KITTITAS COUNTY

MEMORANDUM

TO: All Staff
FROM: Public Works Plan Review Team
DATE: March 30th, 2023
SUBJECT: SP-23-00001 Egan

EGAN SHORT PLAT

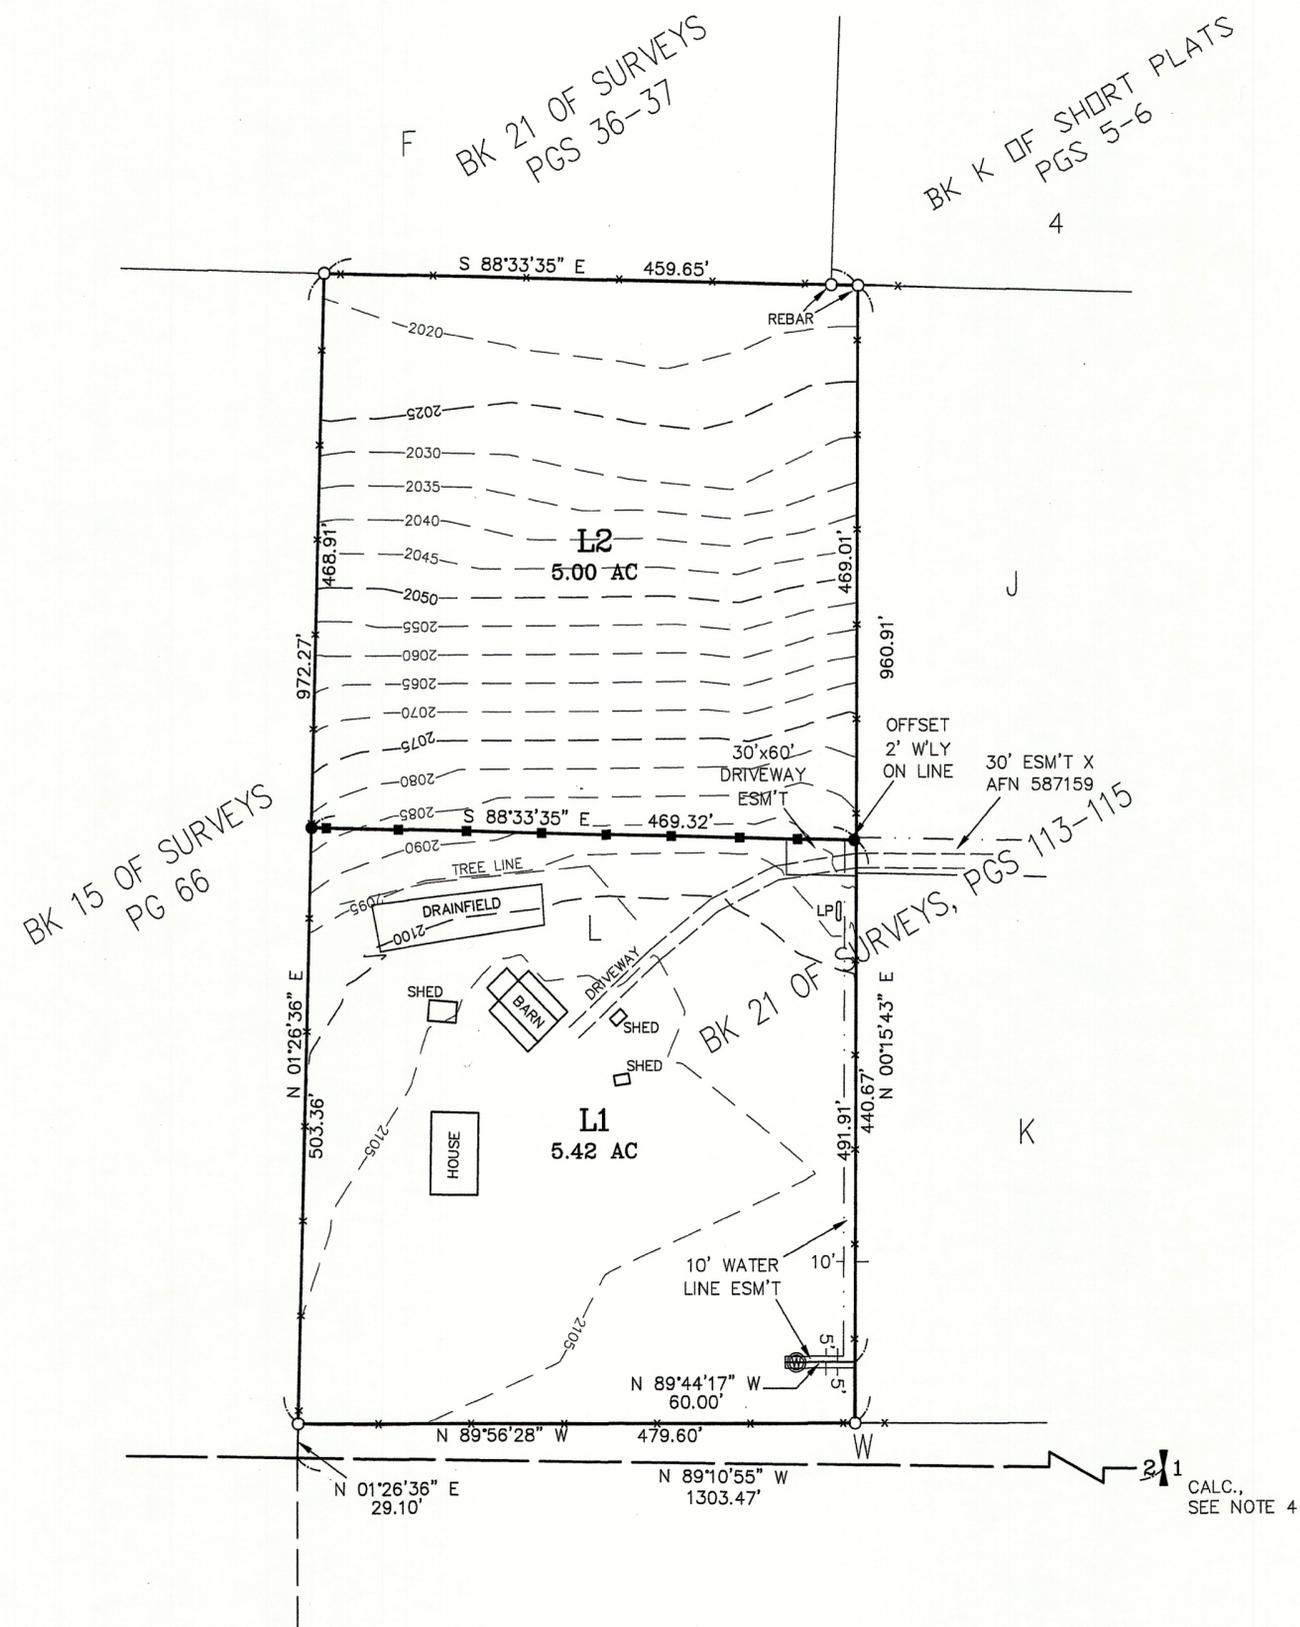
SURVEY	<ol style="list-style-type: none"> 1. Preliminary plat does not meet the requirements of WAC:332-130-145 in regard to contour line sources, vertical datum, and contour accuracy. 2. The 30x60 driveway easement should be labeled as existing, herein created, or created via separate document. (JT).
FLOOD	Parcel #452836 is not located in the FEMA mapped special flood hazard area (100-year floodplain).
WATER MITIGATION/ METERING	<p>The following comments outline the requirements for legal availability of water and metering for the proposed short plat:</p> <p>The applicant must provide legal water availability for all new uses on the proposed lots of this project, which can be provided through a mitigation certificate.</p> <p>In accordance with KCC Chapter 13.35.027, the applicant shall provide one of the following documents before final plat approval:</p> <ol style="list-style-type: none"> 1. A letter from a water purveyor stating that the purveyor has adequate water rights and will provide the necessary water for the new use; 2. An adequate water right for the proposed new use; or 3. A certificate of water budget neutrality from the Department of Ecology or other adequate interest in water rights from a water bank. <p>All applicants for land divisions shall also submit information on "proximate parcels" held in "common ownership" as those terms are defined in WAC 173-539A-030 and otherwise demonstrate how the proposed new use will not violate RCW 90.44.050 as currently existing or hereafter amended.</p> <p>Failure to obtain mitigation before commencement of an activity requiring mitigation shall be a code violation subject to enforcement under Title 18 KCC.</p> <p>Final Plat Notes</p> <p>The following notes shall be placed on the face of the plat:</p> <p>C-1 "Metering is required for all new uses of domestic water for residential well connections and usage must be recorded in a manner consistent with Kittitas County Code Chapter 13.35.027 and Ecology regulations."</p> <p>C-2 "The approval of this division of land provides no guarantee that use of water under the ground water exemption (RCW 90.44.050) for this plat or any portion thereof will not be subject to curtailment by the Department of Ecology or a court of law."</p>
